United States Department of the Interior

May 9, 2023

Re: PR-2020-003484; Mojave Ridge Subdivision

CITY OF ALBUQUERQUE
 PUBLIC WORKS DEPARTMENT
 ENGINEERING DEVELOPMENT GROUP
MOJAVE SUBDIVISION
 GRADING AND DRAINAGE
 GRADING PLAN

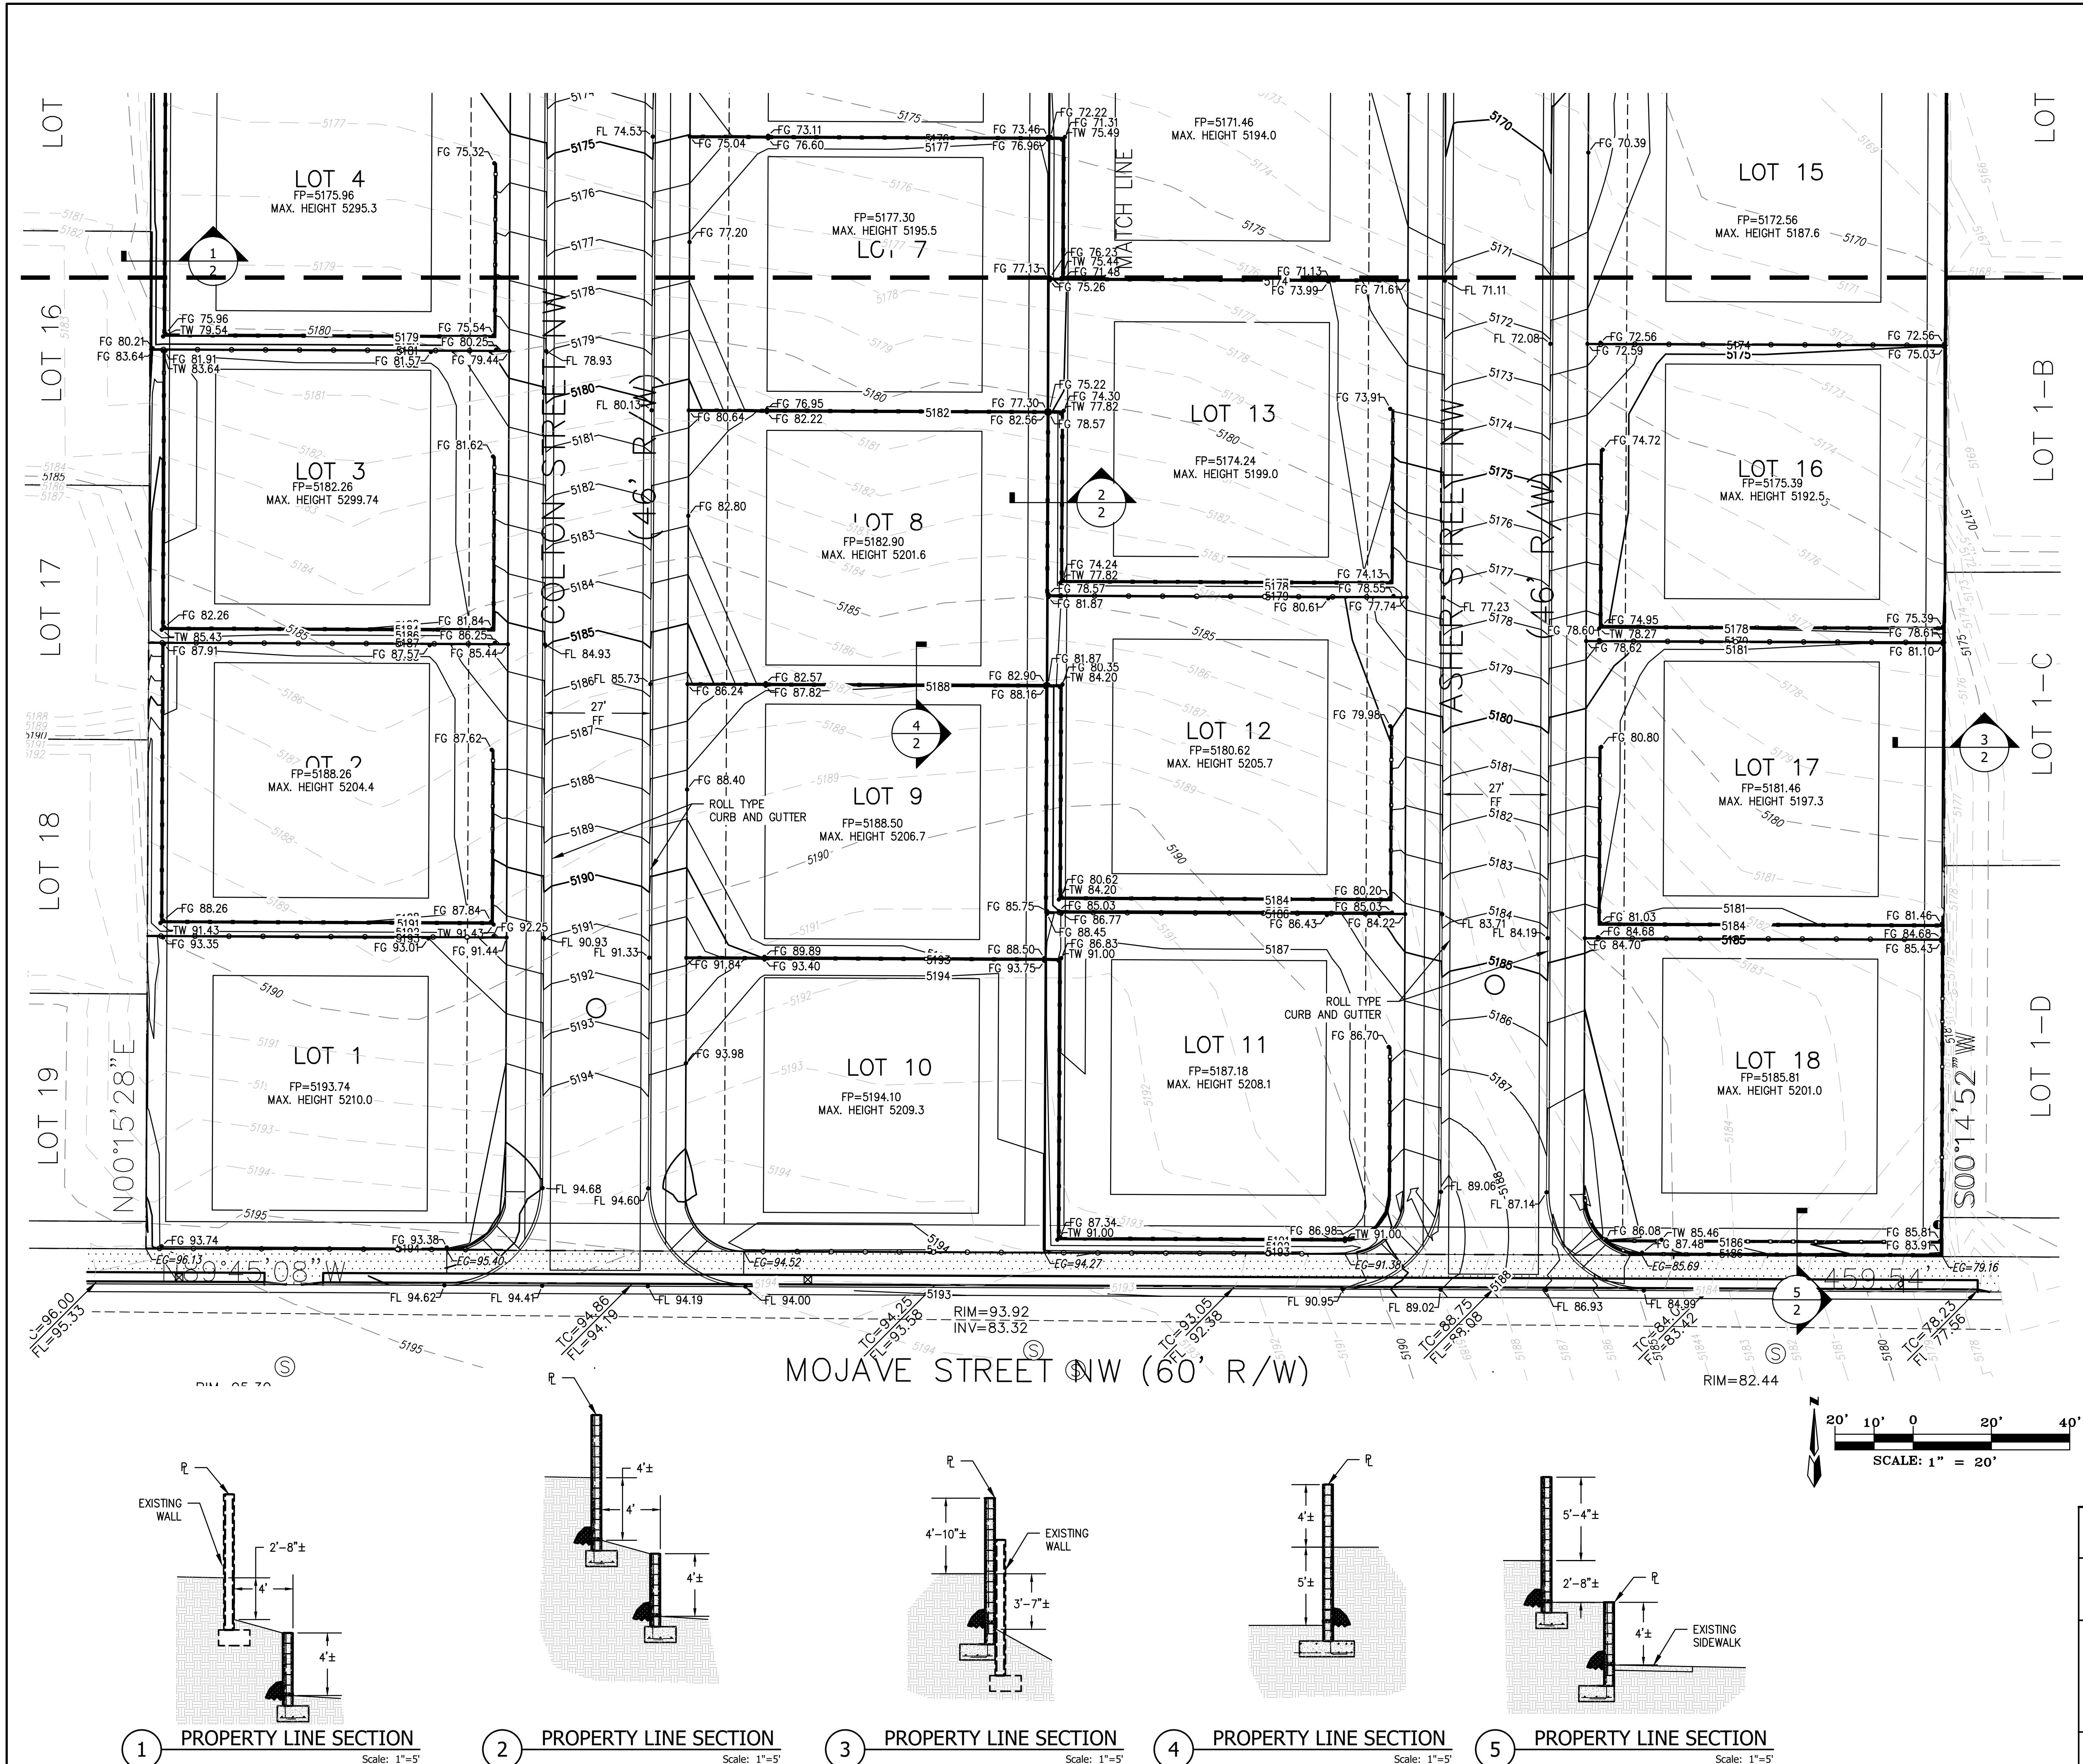
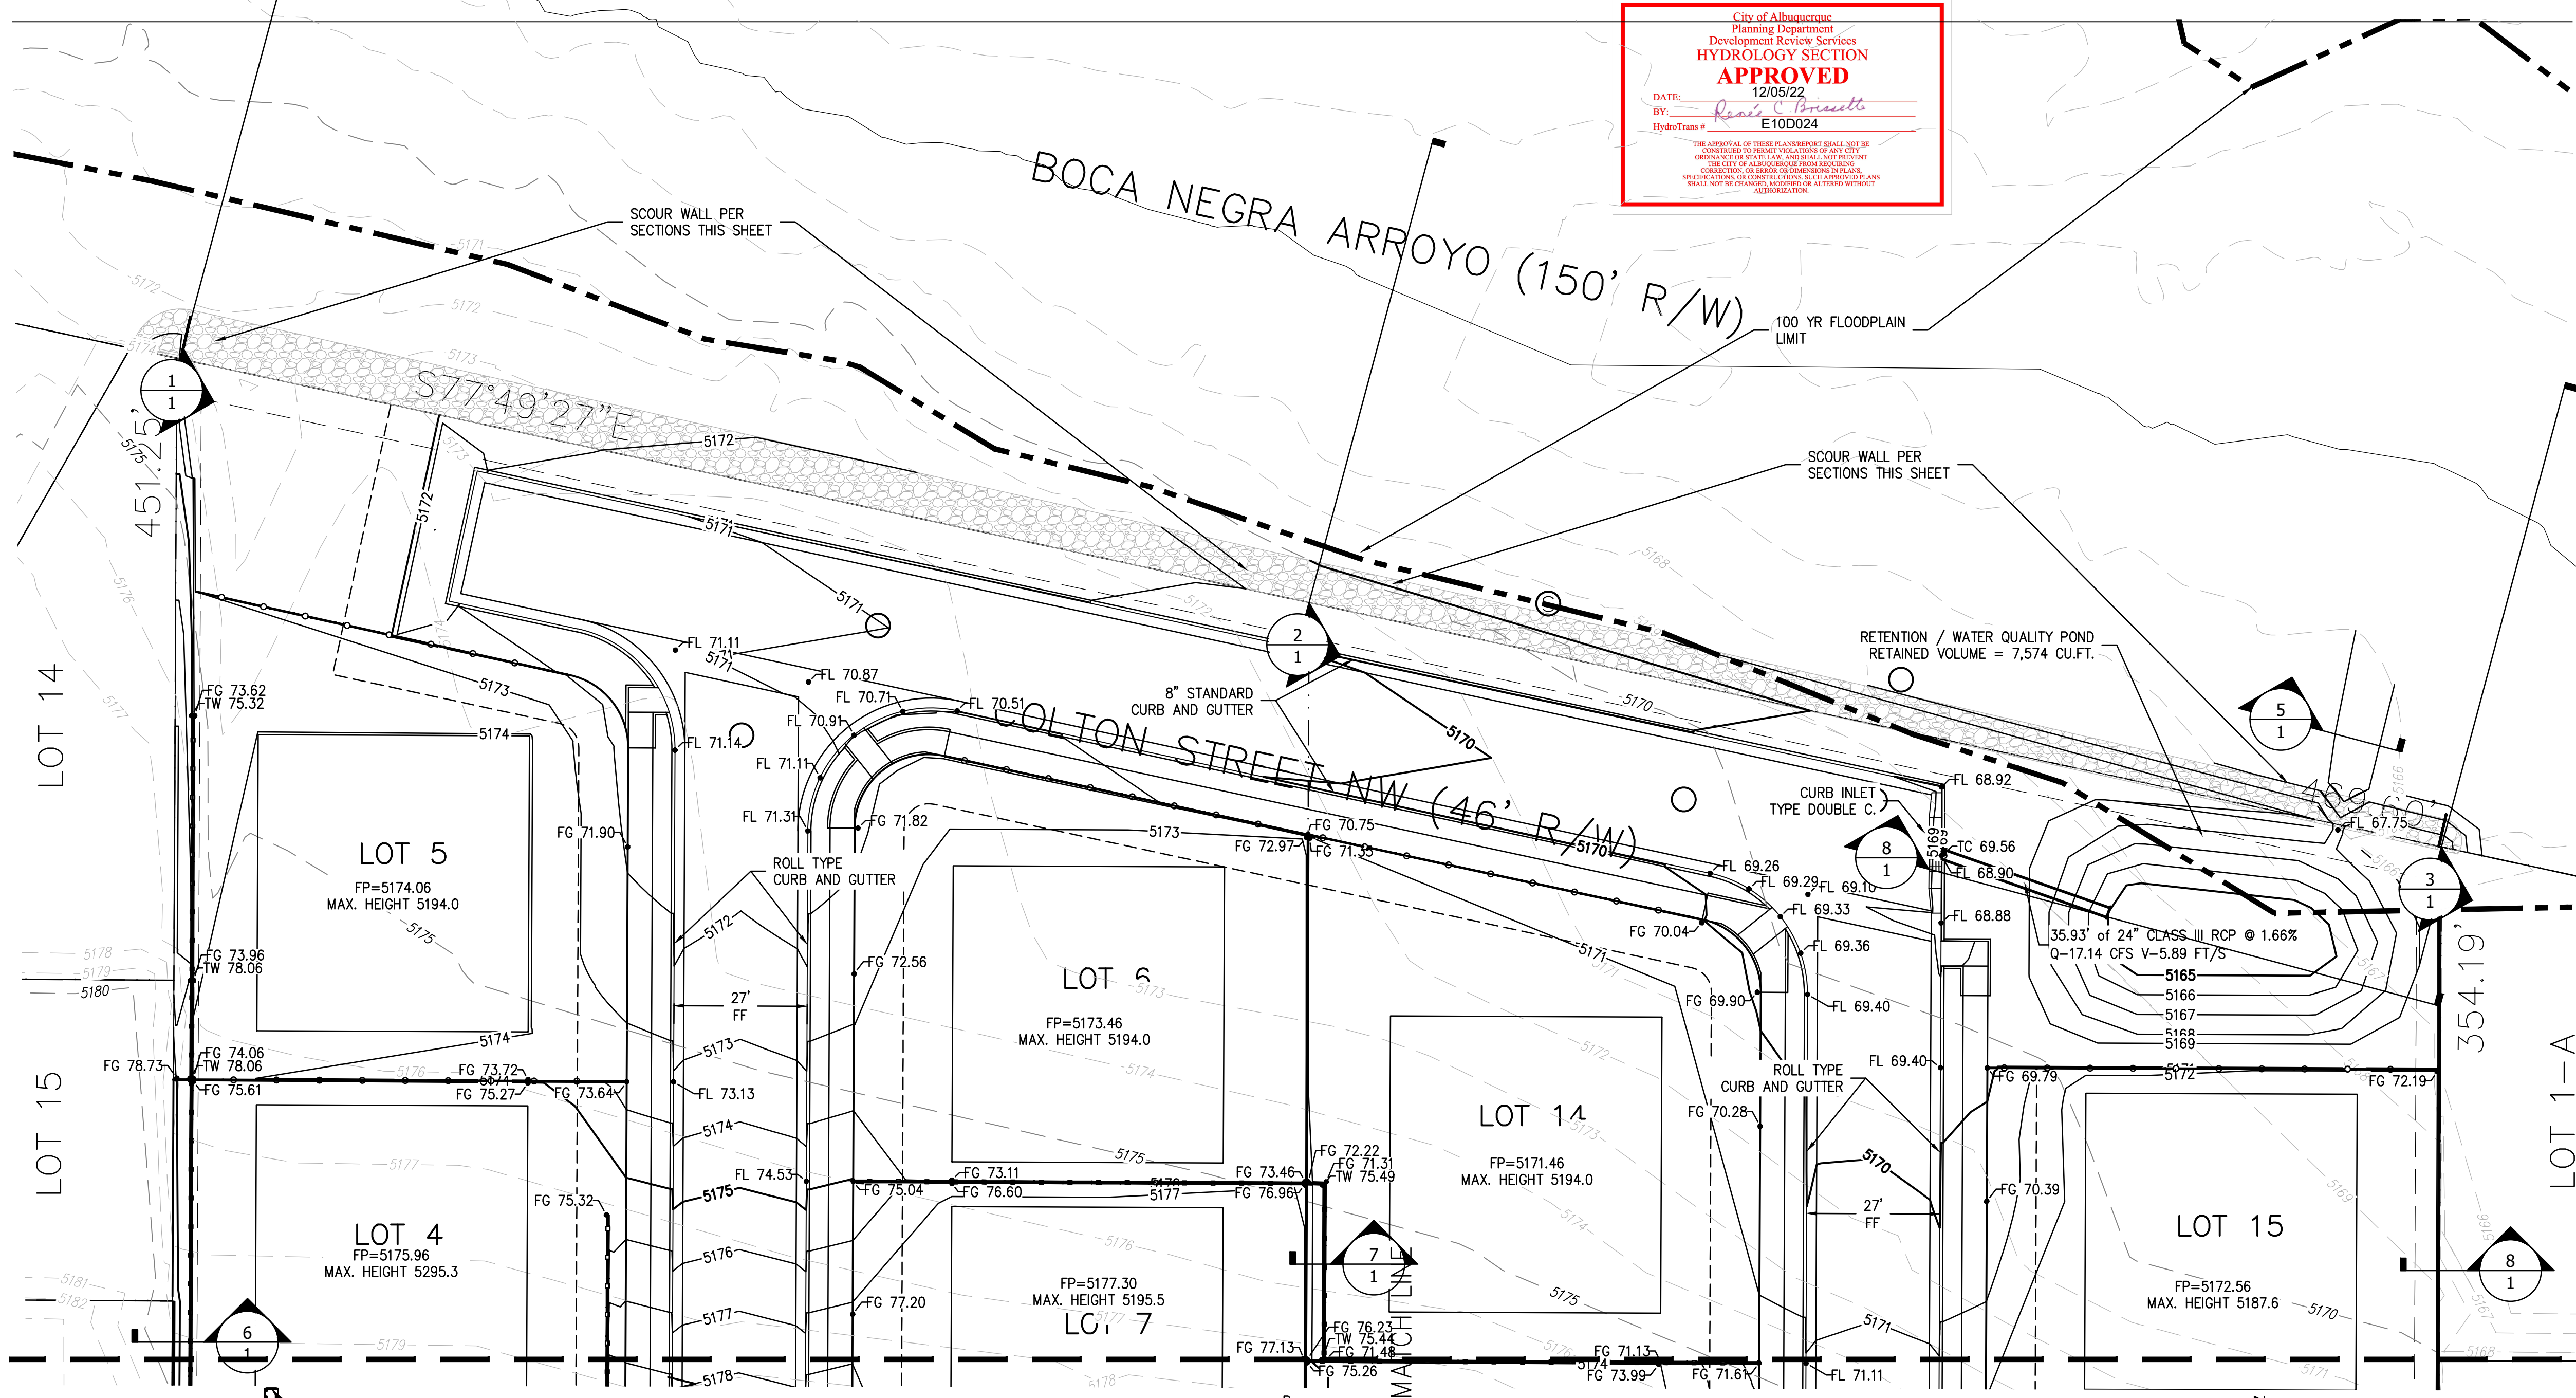
It appears from the site plans that the applicant is proposing to construct a drainage pond in the northeast corner of the property and a drainage structure within or adjacent to Petroglyph National Monument that would drain into the Boca Negra Arroyo located within the Monument. In addition, it appears that the applicant would like to tie the subdivision sewer line into the sewer line in the Arroyo within Petroglyph National Monument. The proposed construction is also within an area zoned NR-PO-B for Major Public Open Space.

On April 26, 2023, the NPS, along with the City of Albuquerque Planning and Open Space Division (OSD) staff met with Mr. Ron Hensley, agent for the applicant, and explained to Mr. Hensley that because a portion of the project is within the Monument, which is co-managed by the NPS and the City of Albuquerque OSD, it would require both NPS and OSD approval. We informed Mr. Hensley at that time, and in subsequent email messages, that he would need to submit his proposed requests formally to the NPS and the OSD to request permission to utilize the Boca Negra Arroyo. We require information from the applicant with details to enable us to analyze the potential effects on Monument resources from the construction activities, plus long-term impacts from drainage into the Arroyo. We are also interested in the long-term maintenance requirements and plans for the scour wall proposed adjacent to the Monument boundary.
